MEMORANDUM

Subject: Mercer Island Parking Management Plan - Response to Comments

This memorandum is a response to the comments and redlines received on May 17, 2021 from the City of Mercer Island for the Mercer Island Mixed Use project. A revised parking management plan has been prepared and submitted with the comment responses incorporated. The comments and responses are also summarized below.

Level P1

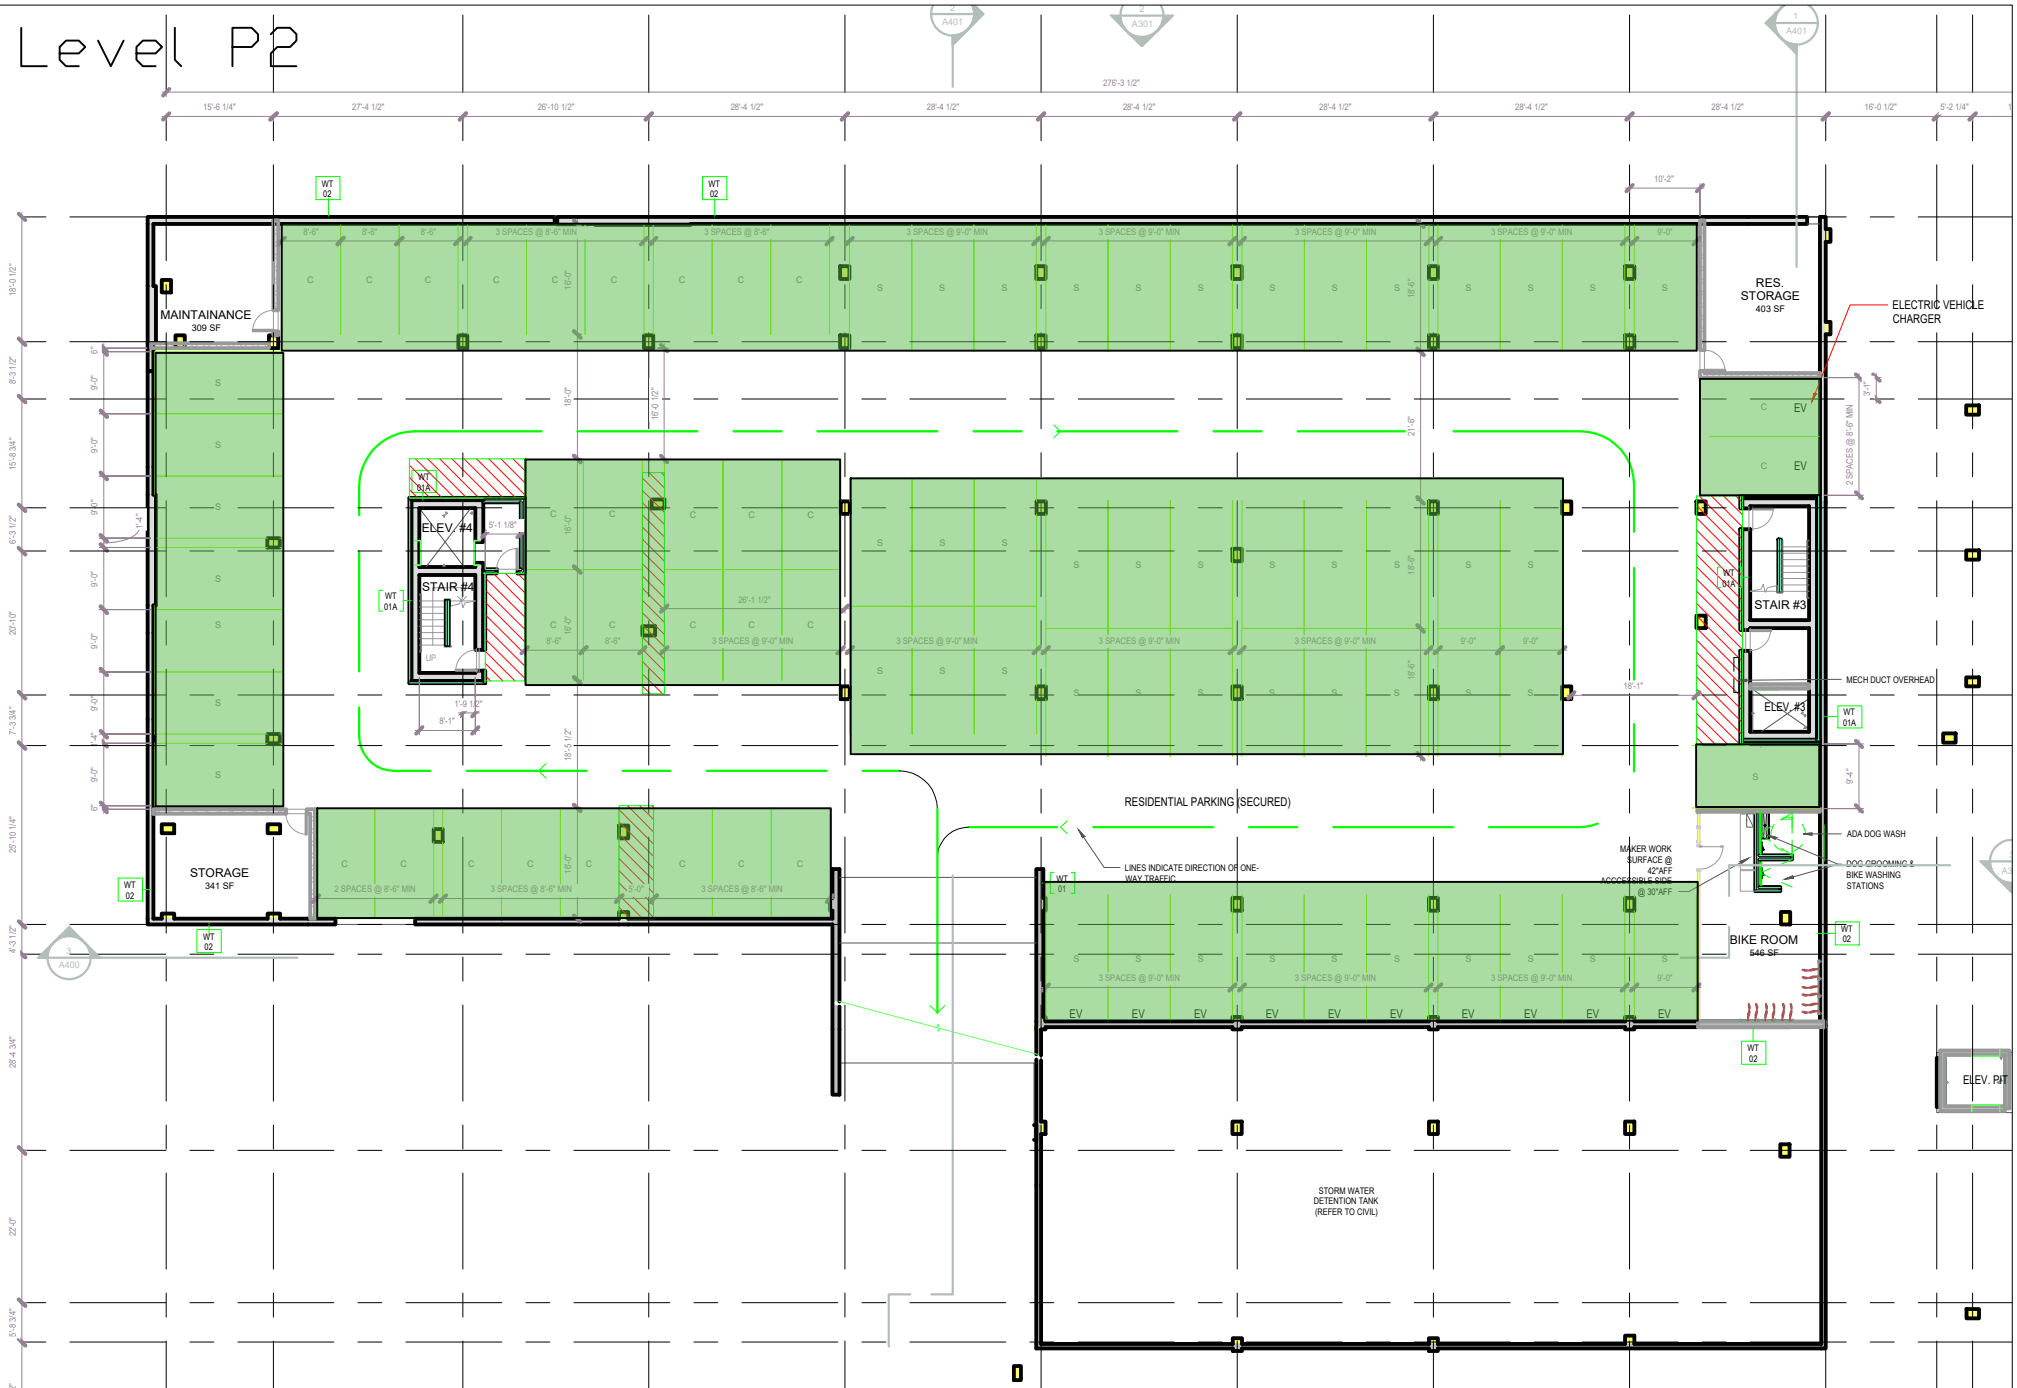
Comment 2: Provide examples of EV stall and EV charging station signs.

Comment 5: Are these EV stalls restricted for parking only for electric vehicles?

Comment 6: Is this an ADA stall and also EV? If so, they don't seem to be compatible uses since only ADA drivers would be able to charge here.

Comment 7: This marked walkway appears to end abruptly at a wall. Is this an error? Shouldn't it connect to a destination such as an elevator or stairway?

Comment 8: Where does this marked walkway take pedestrians?

Comment 9: Seems like you need a ped crossing here.

Comment 10: Is this correct? It shows travel on the left side of opposing traffic rather than the normal right side.

Comment 11: The traffic flows directions on level P1 is difficult to follow. Some lines are green while others are black. I can't tell why. The upper look doesn't seem to have a way out based on the directional arrows.

Comment 12: Please show all appropriate wayfinding on both floor plans.

EV stalls are open to all vehicles, not exclusively for EV vehicles. No additional signage or stall markings are identified. The charging equipment will be used to identify the EV use.

EV stalls are open to all vehicles, not exclusively for EV vehicles.

Correct, this was done intentionally to provide charging station for ADA users. Parking stall not only for EV vehicles.

Designated walkways removed from plans. Designated walkways not proposed on-site.

Designated walkways removed from plans. Designated walkways not proposed on-site.

Designated walkways removed from plans. Designated walkways not proposed on-site

Plans revised to correct direction of travel.

Plans revised to have consistent color scheme.

Owner plans to hire signage consultant at later date.
